Re: Bus Connects Kimmage to City Centre core bus corridor scheme
Kimmage, Dublin

Bus Connects Dublin - Kimmage to City Centre Core Bus Corridor Scheme

Bord Pleanála Case reference: HA29N.317660

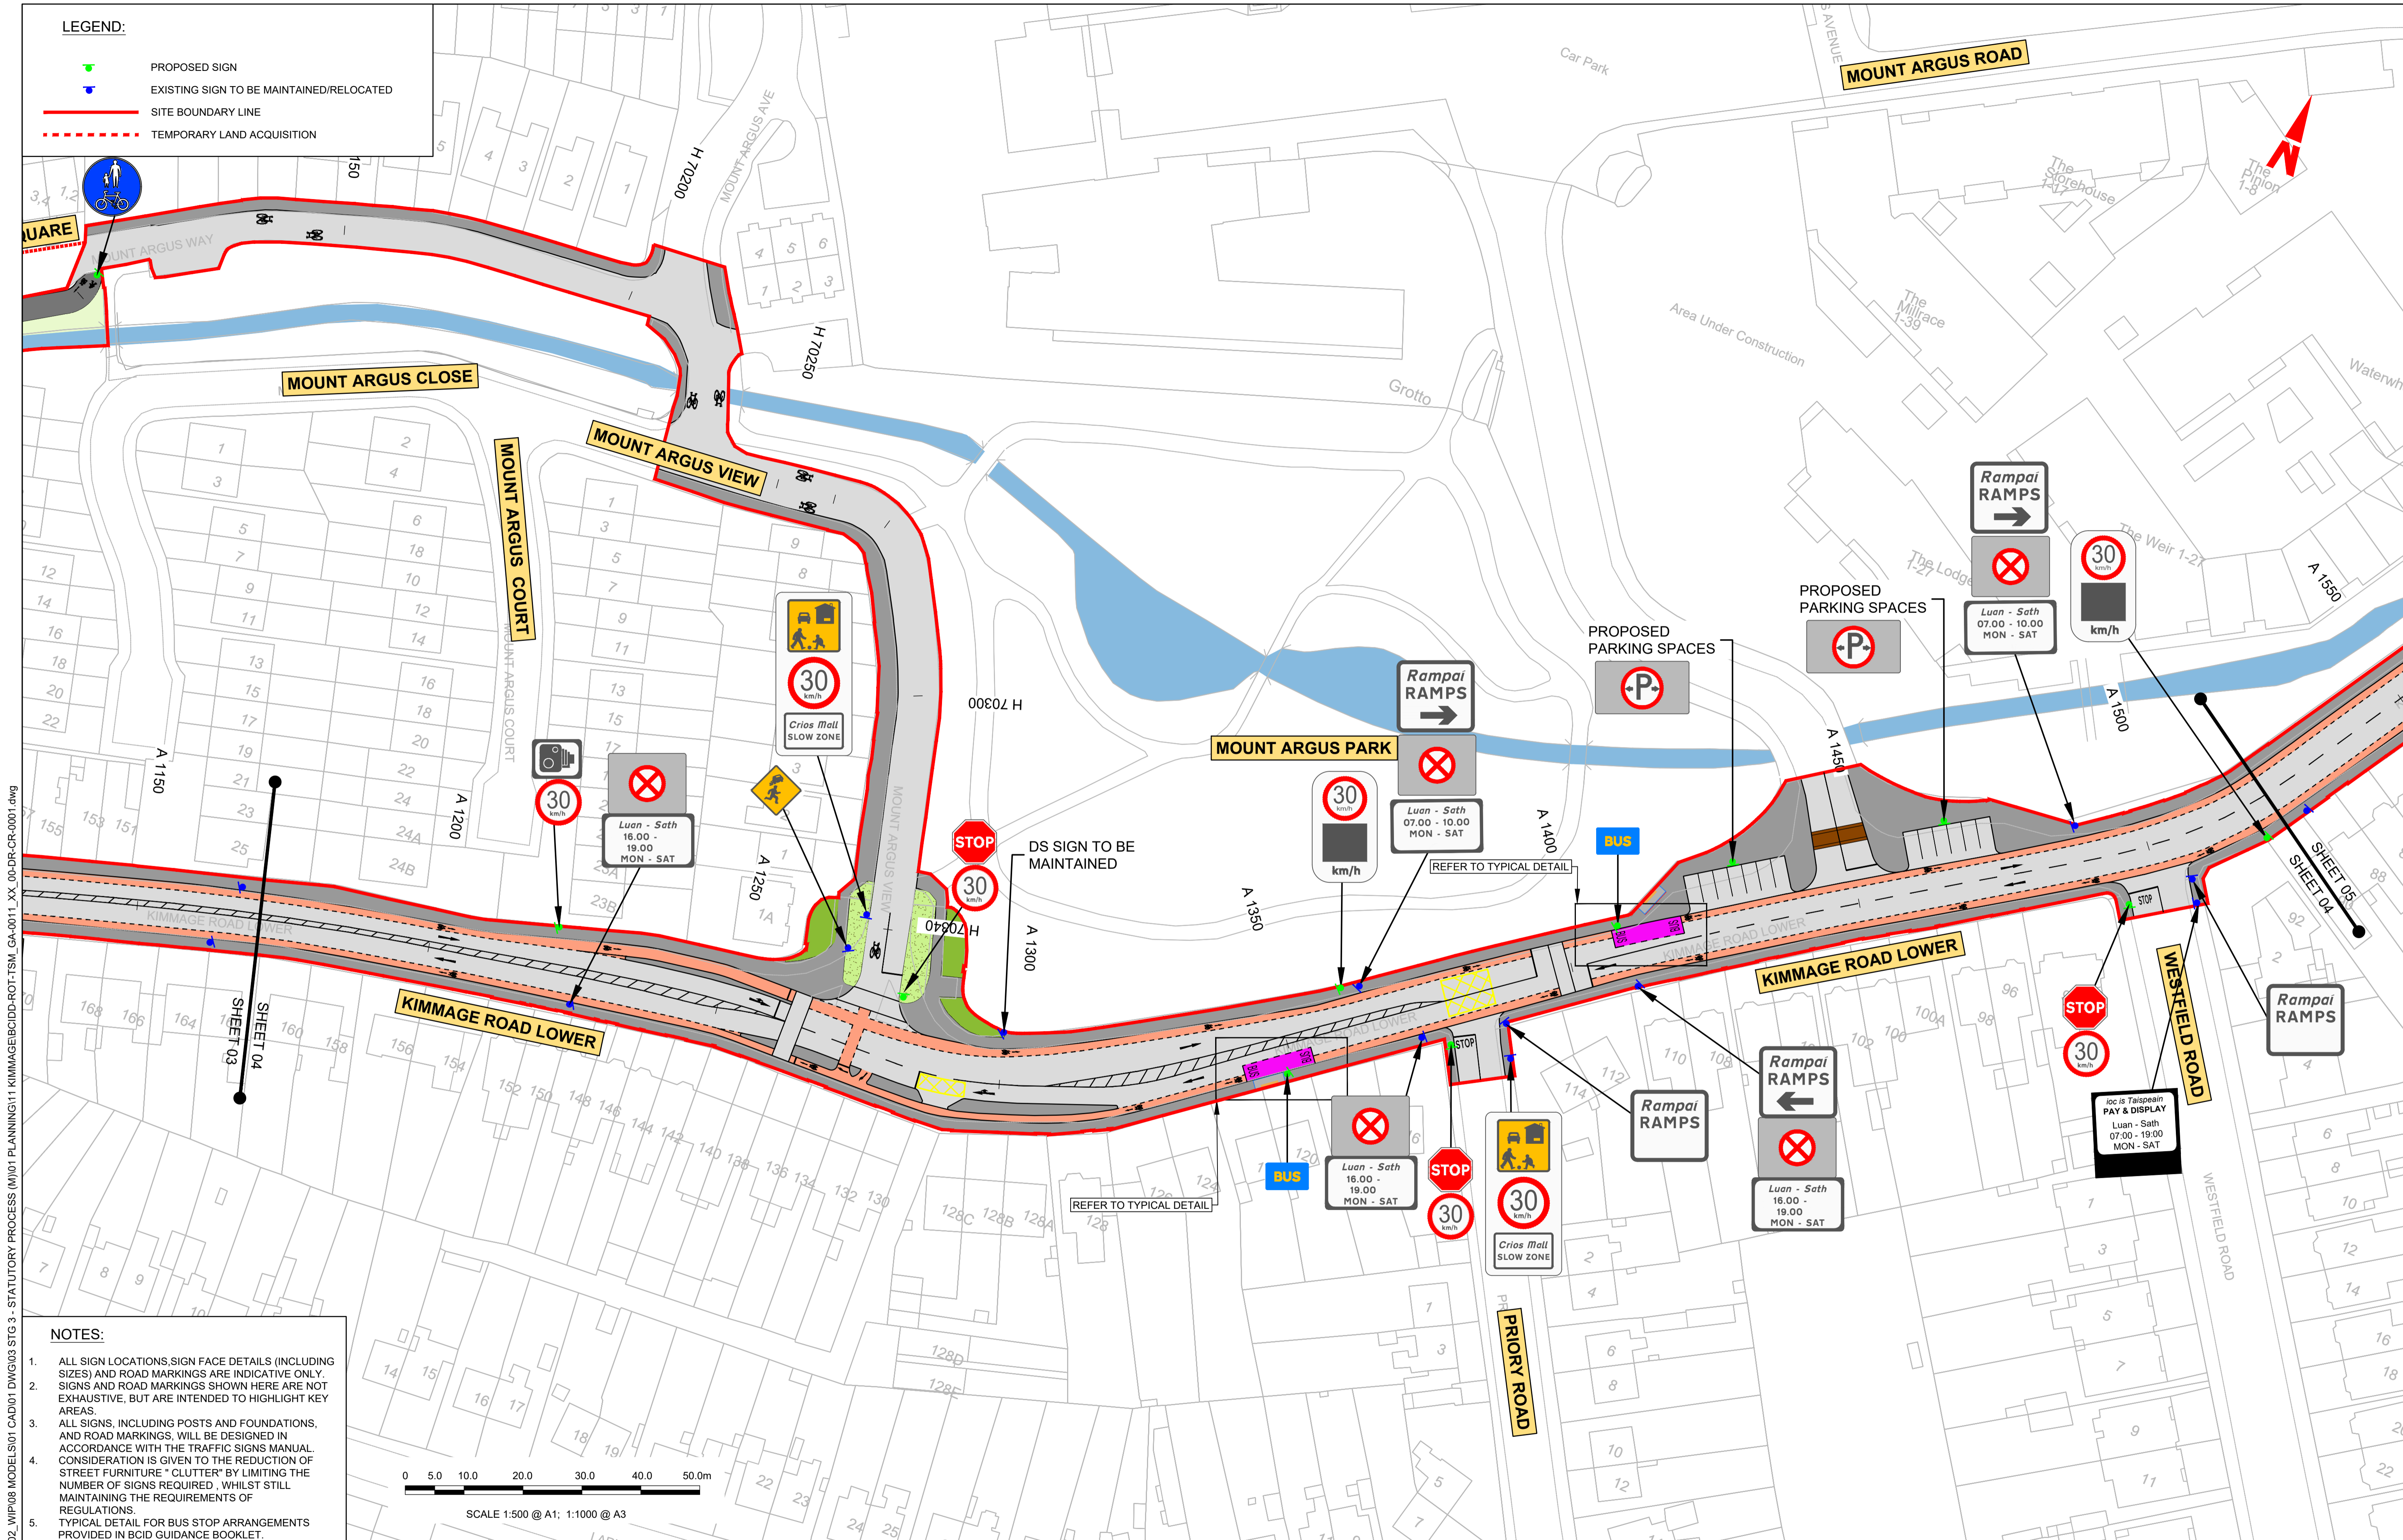
- This scheme drawing appears to suggest that allowance has been made for vehicular access and egress of the lane between 128C and 130 Kimmage Road Lower. Should the scheme be approved, this MUST be retained. If the road markings do not currently cater for unencumbered access and egress then it MUST do so. (**Note:** This lane is used for vehicular rear access for up to c.28 properties*, with that lane being the ONLY vehicular access for my garage to my property at 128A Kimmage Road Lower and the only front and primary vehicular and home occupants' access for properties 128D and 128E Kimmage Road Lower. (see **Appendix 2**).

Road markings – provision for and maintenance of lane vehicular access: This scheme drawing appears to suggest that allowance has been made for vehicular access and egress of the indicated lane – should the scheme be approved, this **MUST** be retained; if the Road markings do not currently cater for that unencumbered access and egress then it **SHOULD** do so.

Road markings – provision for and maintenance of lane vehicular access: This scheme drawing appears to suggest that allowance has been made for vehicular access and egress of the indicated lane – should the scheme be approved, this **MUST** be retained; if the Road markings do not currently cater for that unencumbered access and egress then it **SHOULD** do so.

Note: This lane is used for vehicular rear access for up to c.28 properties*, with that lane being the **ONLY FRONT and PRIMARY** vehicular (and home occupants) access for properties 128D and 128E Kimmage Road Lower.

I request that any road markings and traffic signage provide for the unencumbered access and egress to the lane between 128C and 130 Kimmage Road Lower.
